**Proposal:** Discharge of condition 6 (segregated pedestrian and cycle path) of 21/03177/F

- 2.1. This submission seeks to discharge condition 6 of 21/03177/F, which relates to the details of the segregated pedestrian/cycle path.

Drawing Title
**Access Road (Phase 3)
Link Path Details**

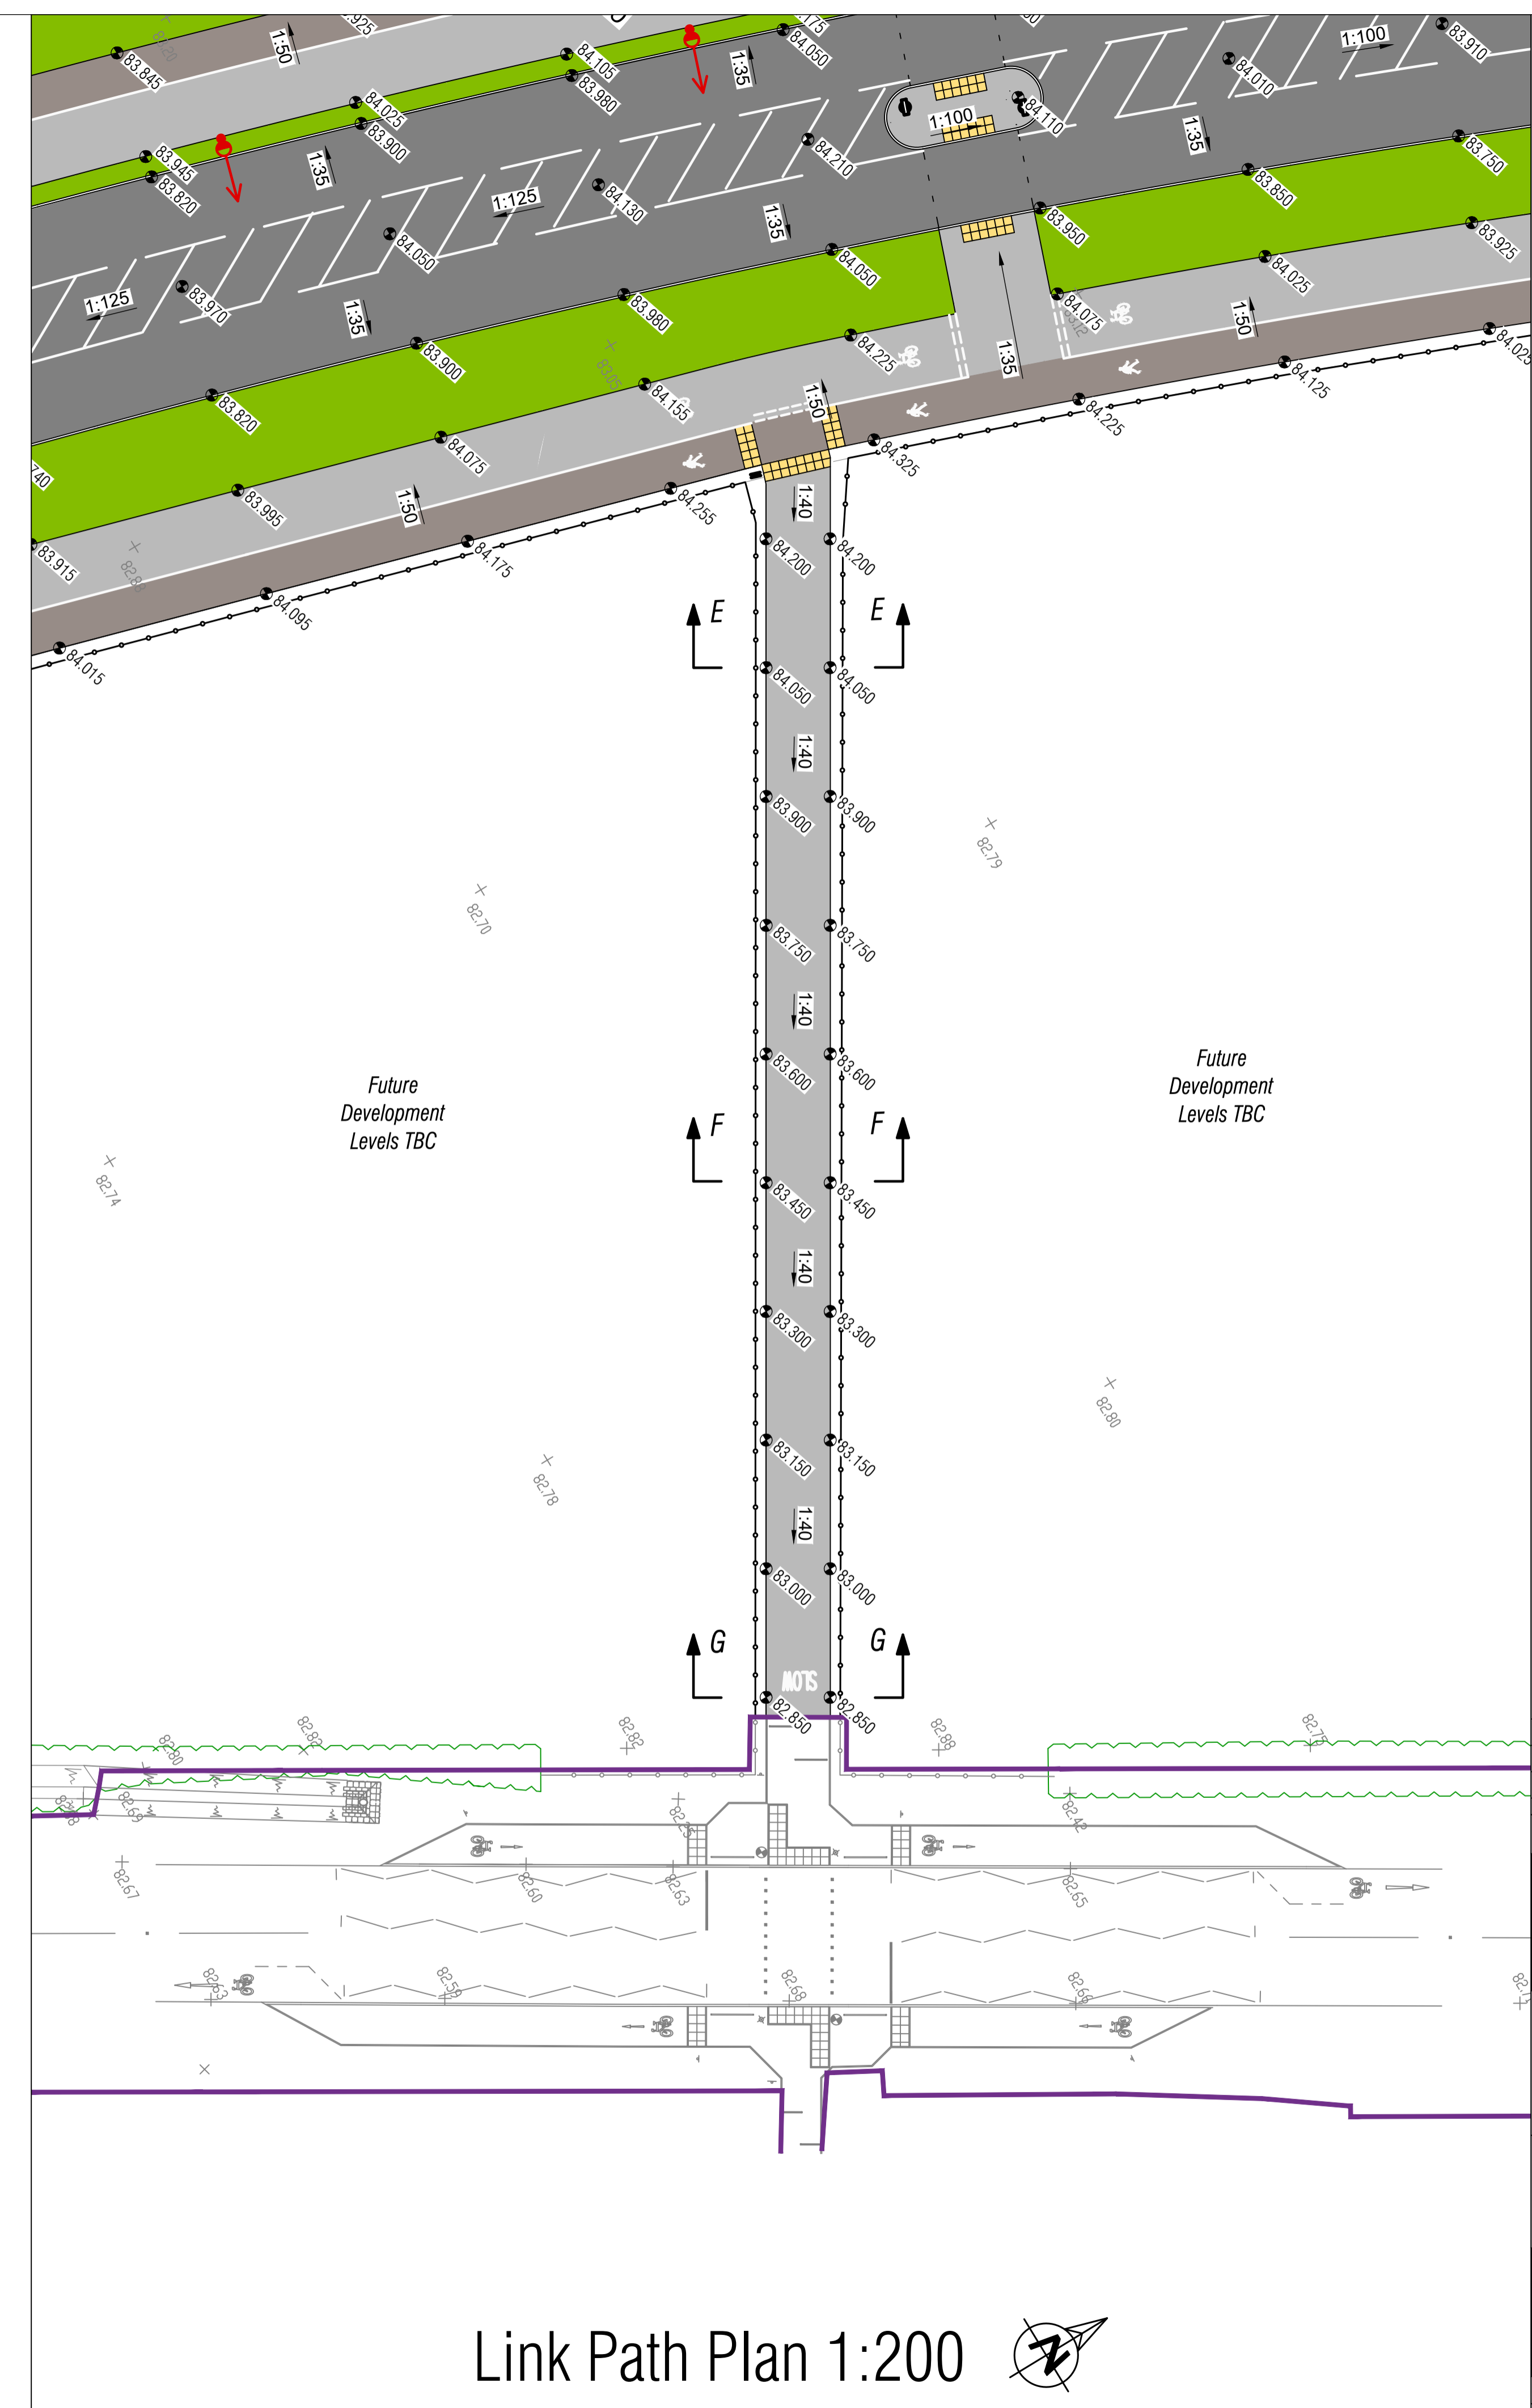
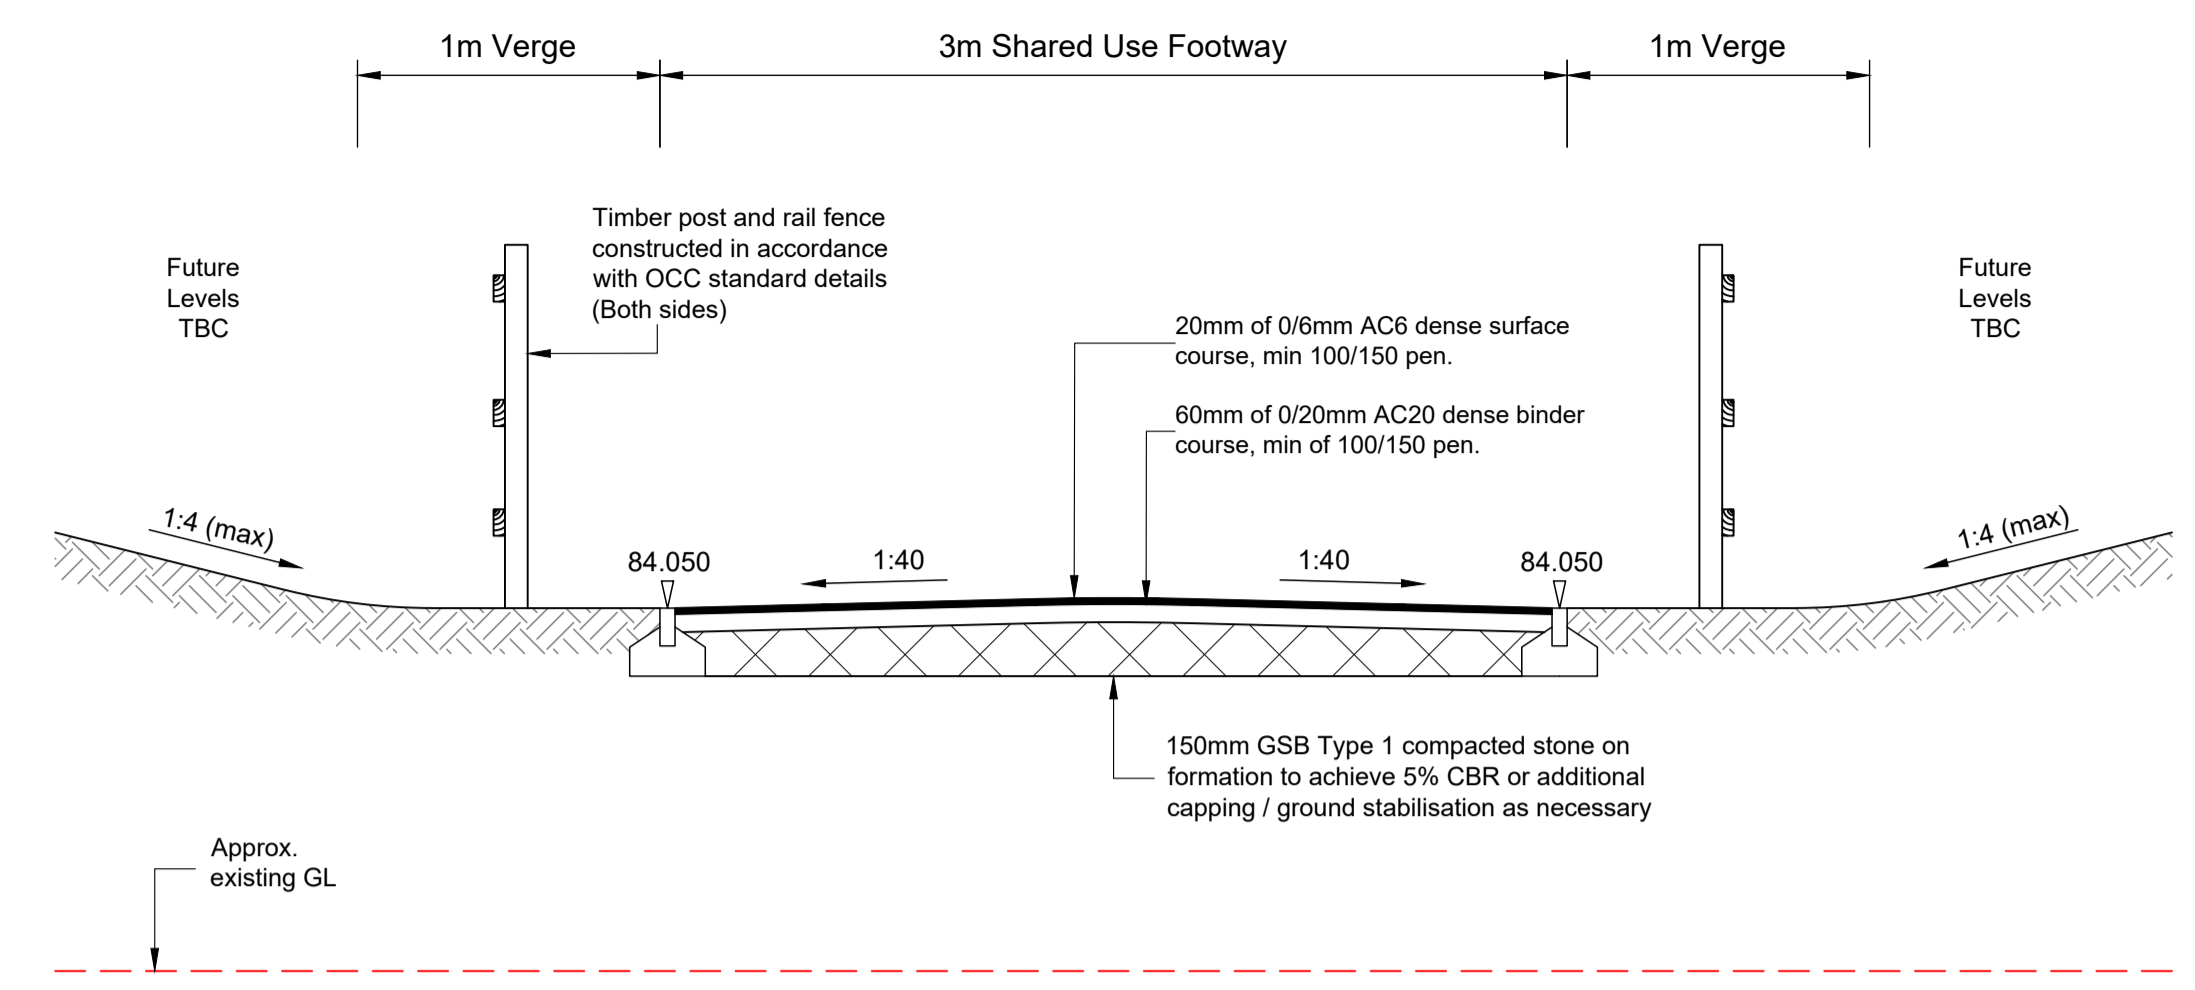
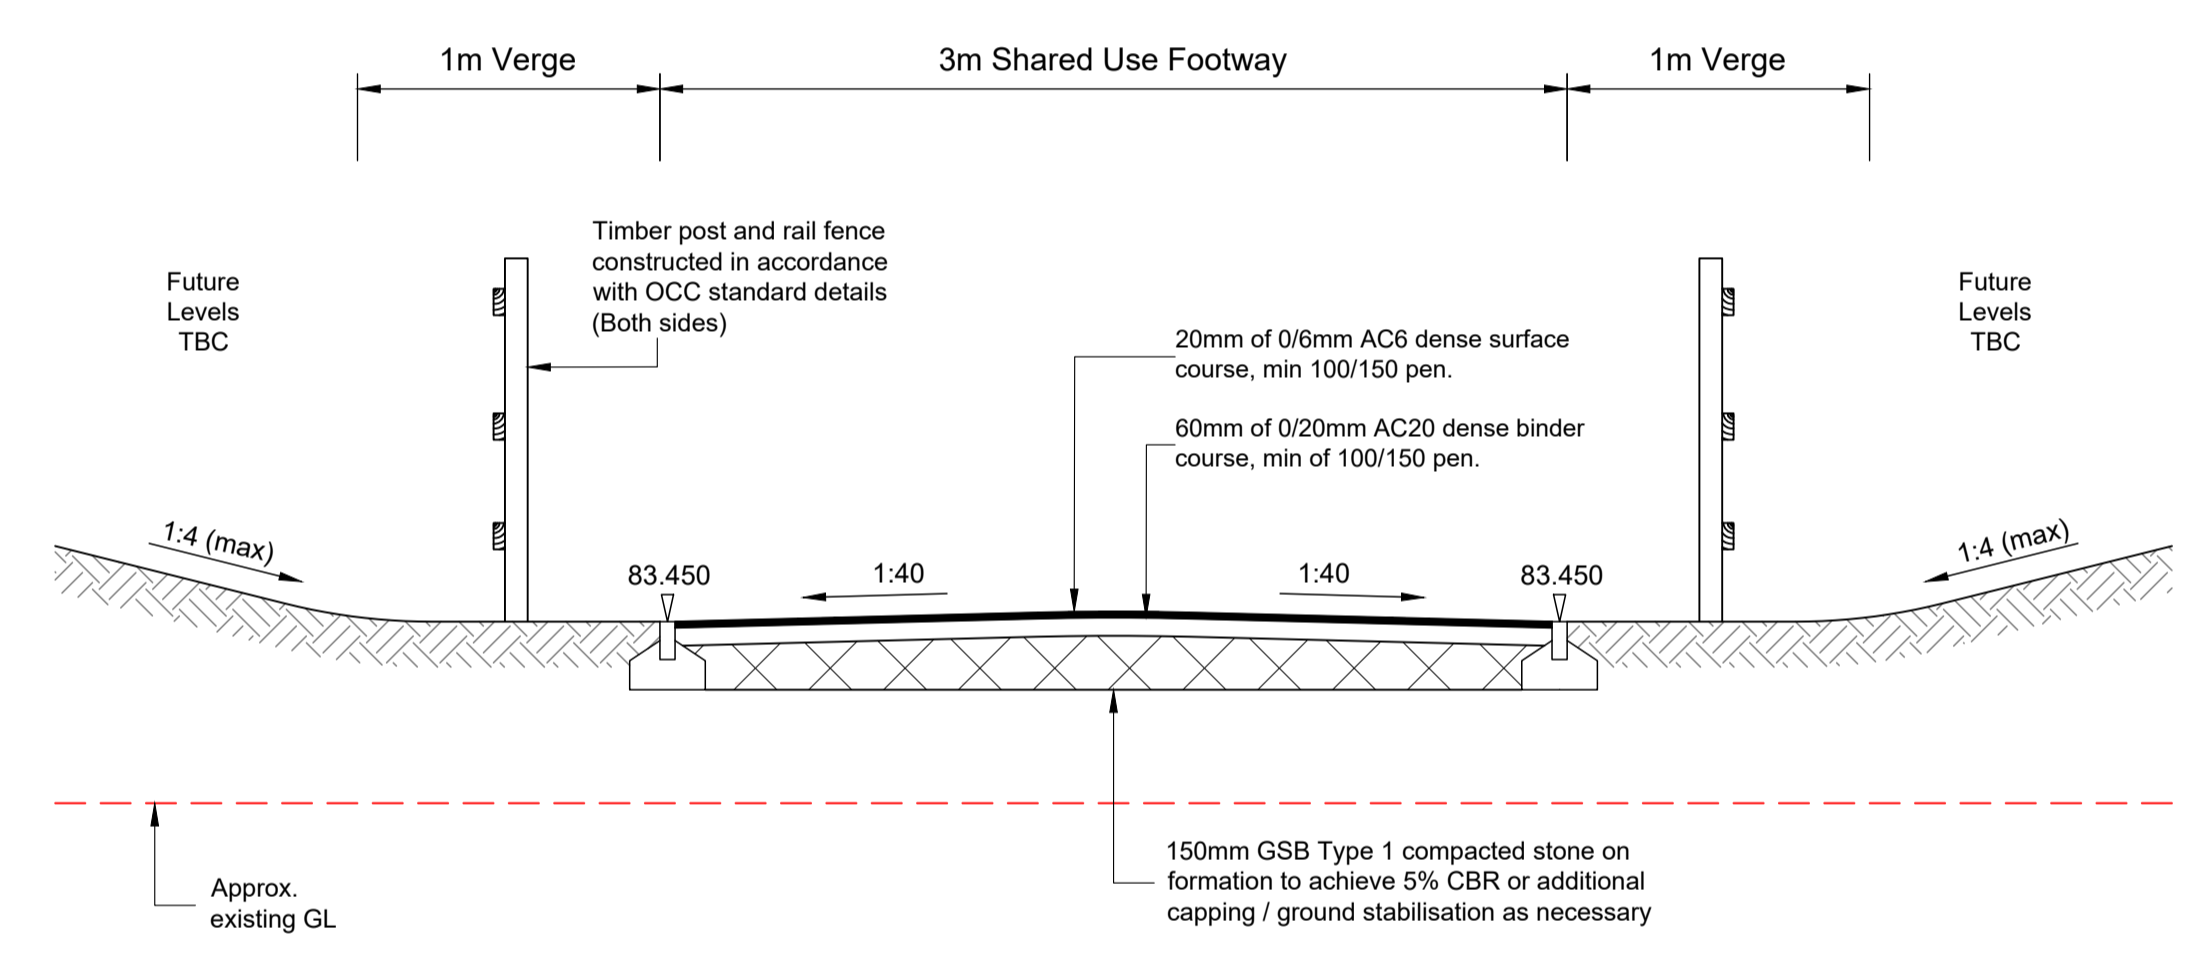
- 6.2. The LHA have reviewed the information and are content with the details. The path will link to a new toucan crossing on Howes Lane, which is the subject of a S278 application to OCC, whereby the detail will be agreed. It's assumed that this path will be part of a S38 submission, whereby the technical detail will be agreed. However, it is acceptable in principle. The path is proposed as a 3m wide shared use path, which is in line with the planning permission and acceptable here as in the longer term the path will have a relatively low level of usage, the main route being provided

via the paths alongside the new strategic link road. Drawing 0002-1001 P0 Site Roadway Lighting, shows that the path will be lit.
